**WELWYN HATFIELD COUNCIL – DEVELOPMENT CONTROL**  
**DELEGATED REPORT**

<b>APPLICATION No:</b>	<b>S6/2010/2604/FP</b>
------------------------	------------------------

The proposed development would involve the erection of a single storey rear conservatory. The proposal would be sited to the centre of the rear elevation and approximately have a maximum depth of 5.2m by a width of 4.6m , with a pitched roof to a height of 3.7m.

Scale 1:100, 1:200, 1:20
Date Oct. 2009
Dwg Ref A/748

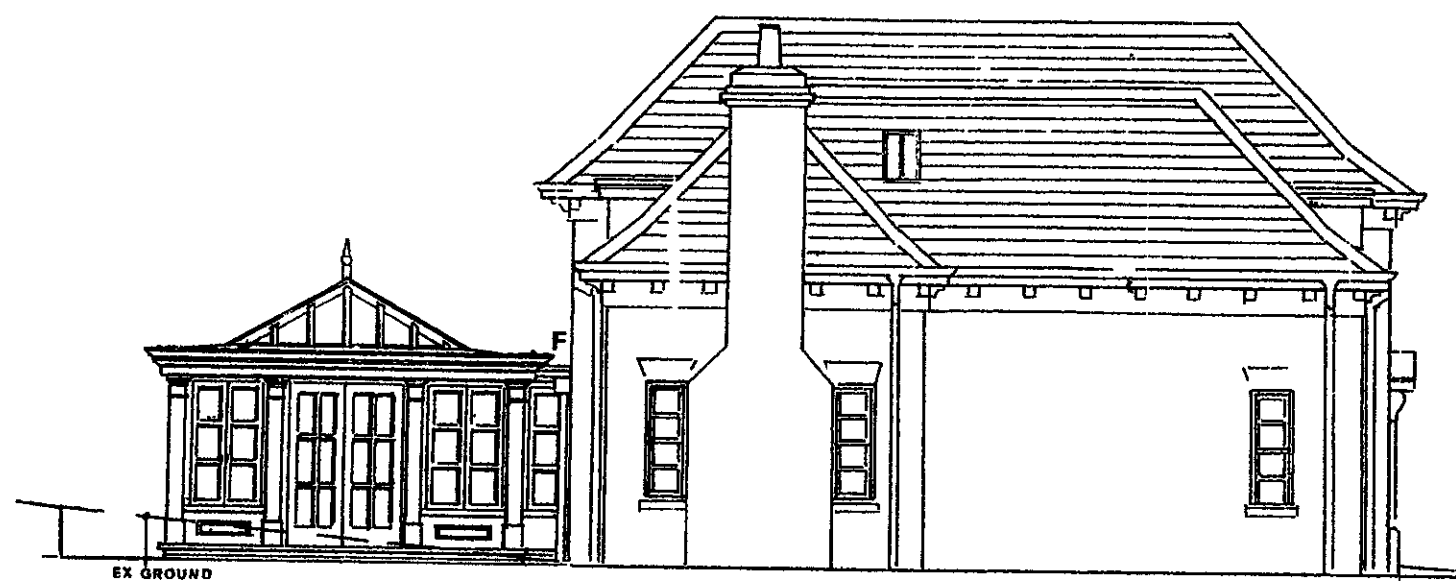
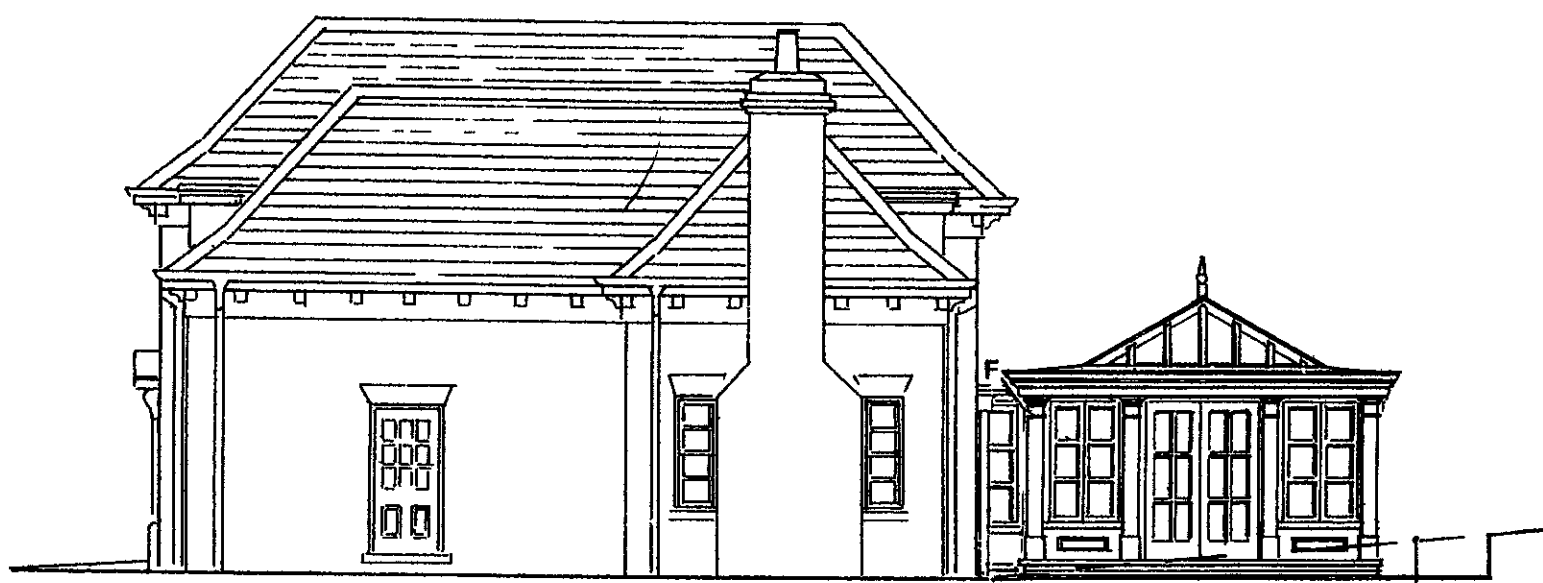
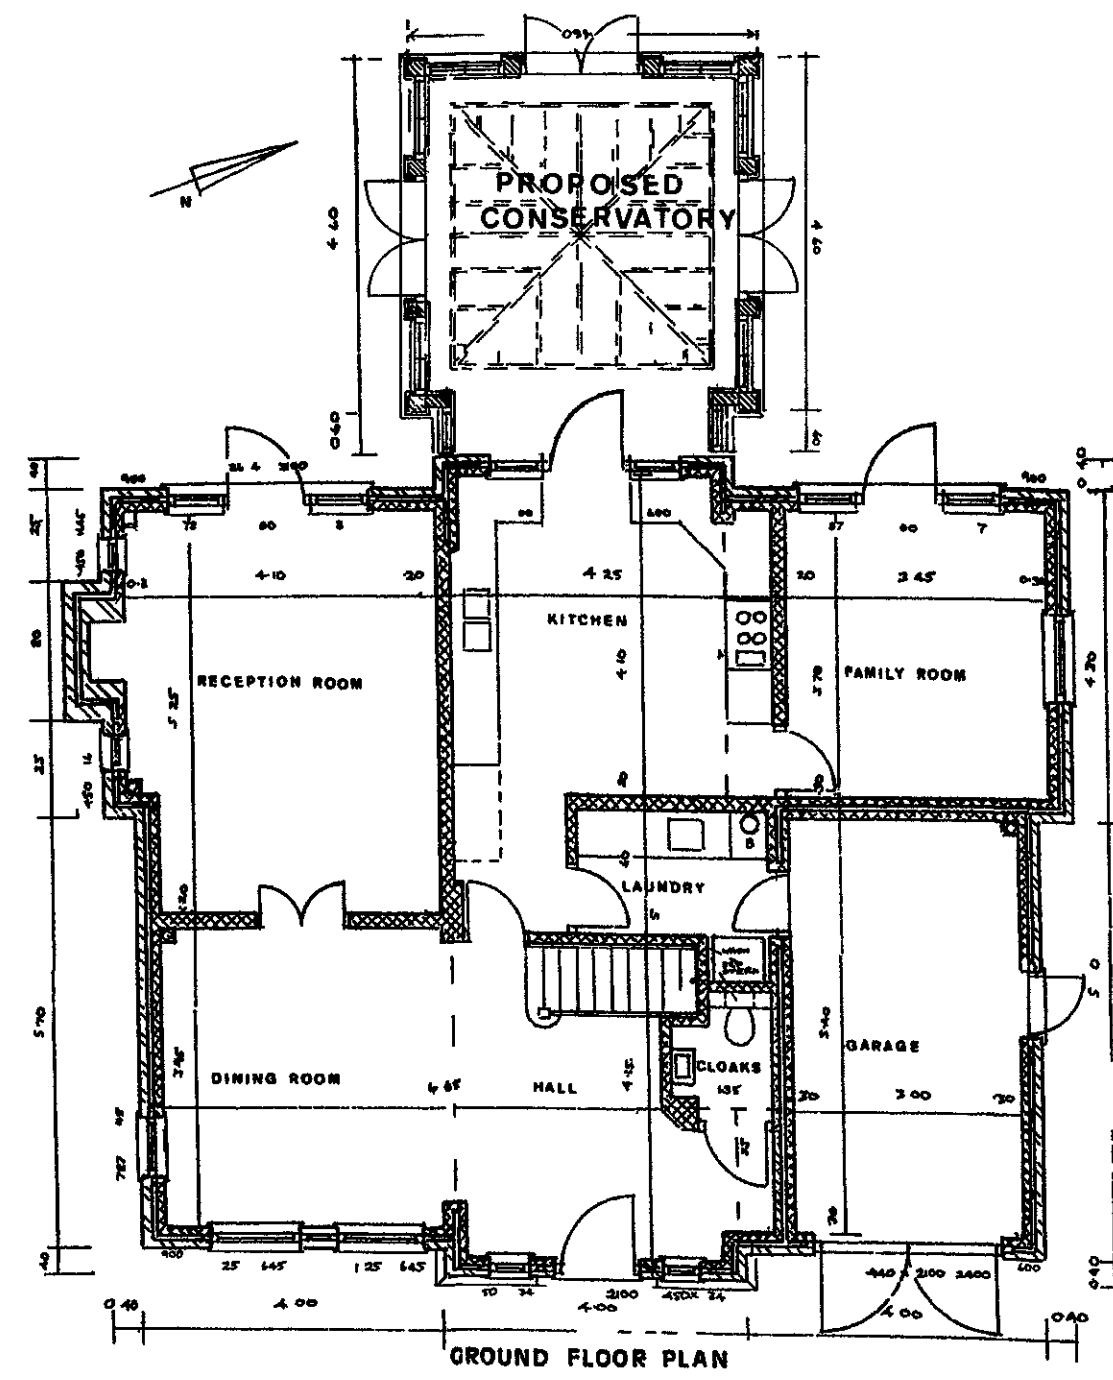
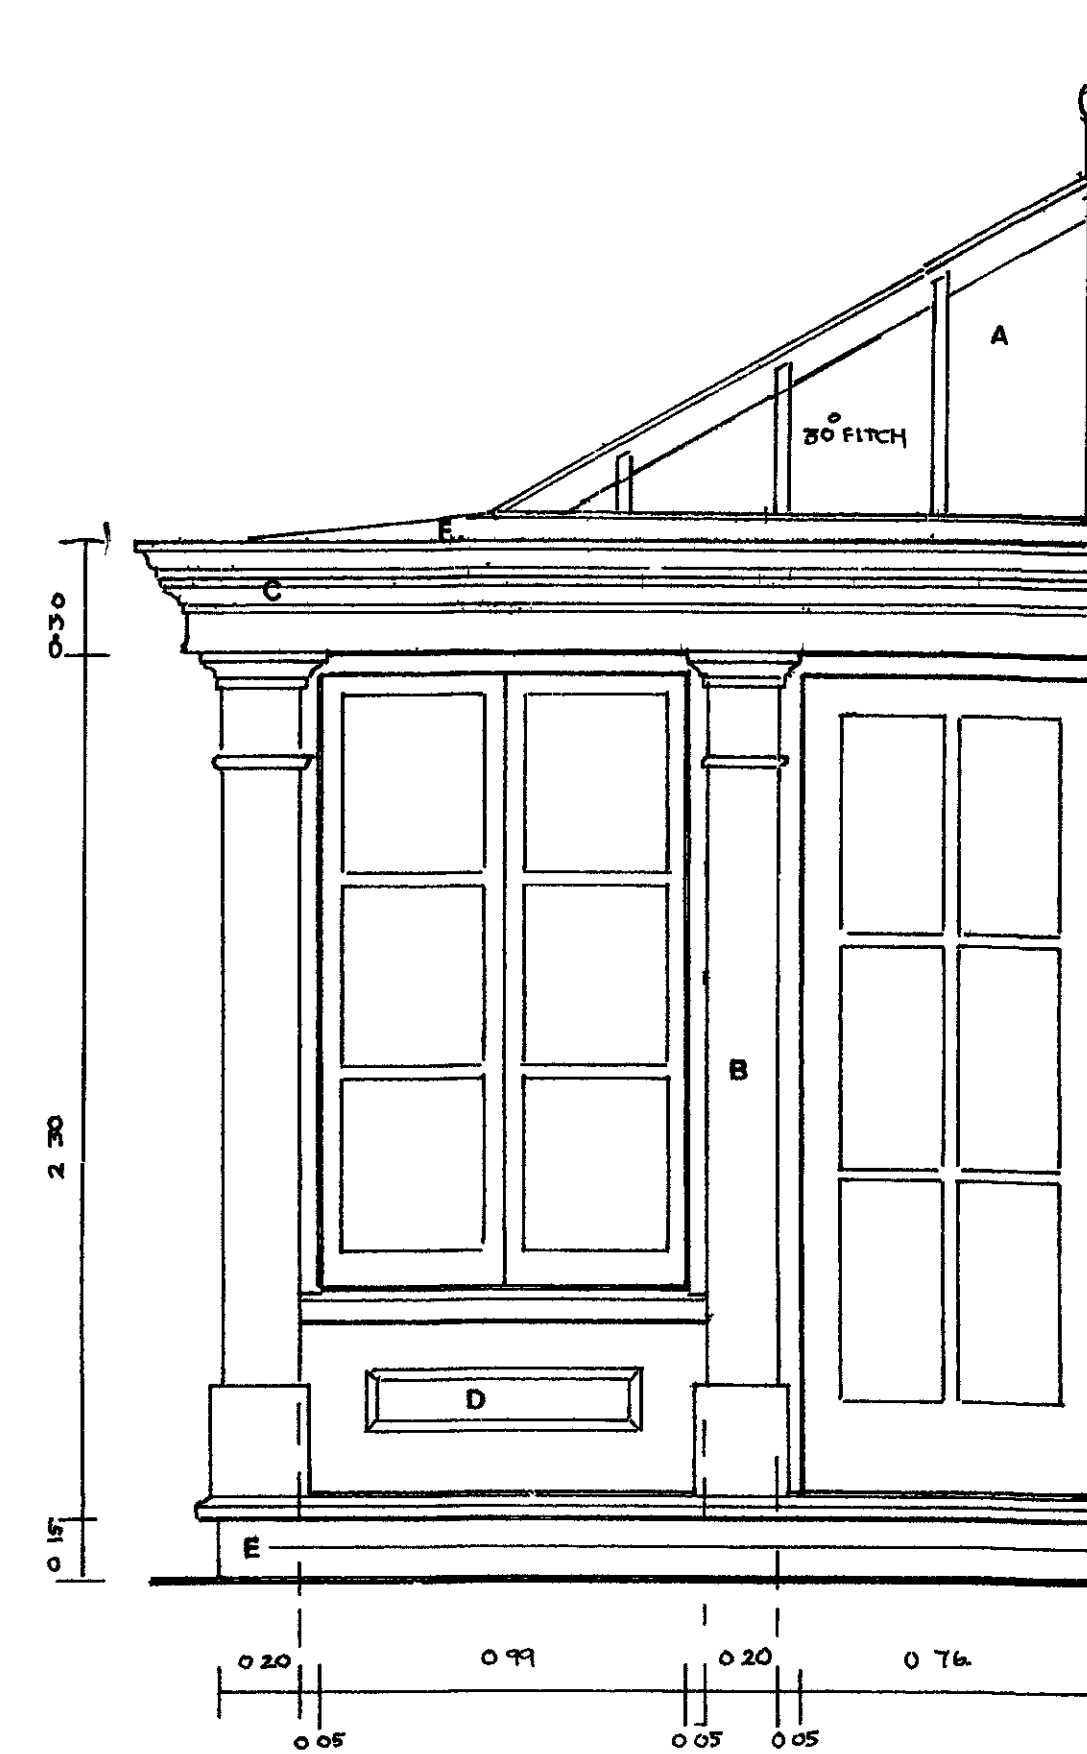
The proposed extension would have a depth of 5.2m from the rear of the existing dwelling. The proposal would be relatively large when compared to the depth of the existing (replacement) dwelling and overall floorspace that would be created. As a result it is considered that the proposal would fail to comply with both parts of the criteria of policy RA3 (i and ii) – when considered against the original dwelling, the proposal would represent a disproportionate increase and have an adverse visual impact in terms of its prominence and design. Its bulk and size per se are considered acceptable within this Green Belt location. Notwithstanding that the development is located to the rear of the dwelling and has been sited to the central part of the dwelling, this is not considered to overcome the 'harm' to the Green Belt (para 3.2 PPG2). This view has been considered within previous appeal decisions (APP/C1950/A/06/2010413) and whilst this decision is some time back, both local plan and national policies have not changed in this time. not appear disproportionate in size when compared to the original dwelling.

2. The proposal has been designed to reflect the appearance of the main dwelling with matching timber casements and brickwork. Although the depth of the proposal would be relatively large, the overall size and design would be subordinate to the existing dwelling.

Due to the proposal being single storey with a hipped roof, the bulk and mass would be limited and it would not appear overly prominent when viewed from the surrounding area. The proposal would not have an adverse impact upon the visual amenity of the surrounding Green Belt area.

3. The proposed development would be sited to the rear of the property and have a reasonable distance from the side boundaries of the plot. The adjacent properties are both detached and set away from the shared boundary. The proposal would have side facing windows and therefore any overlooking of the adjacent occupiers must be assessed.

- 1. The proposed conservatory would, by reason of its size, siting and scale when considered cumulatively against the size of the original dwelling which existed prior to 2007, be disproportionate in scale to the size of the original dwelling, resulting in a significant increase in built form within this rural Green Belt location and as such, would have a harmful effect on the openness and character of the Green Belt. The proposed extension is therefore contrary to policy RA3 of the Welwyn Hatfield District Plan 2005 and PPG2. No very special circumstances have been shown to exist.
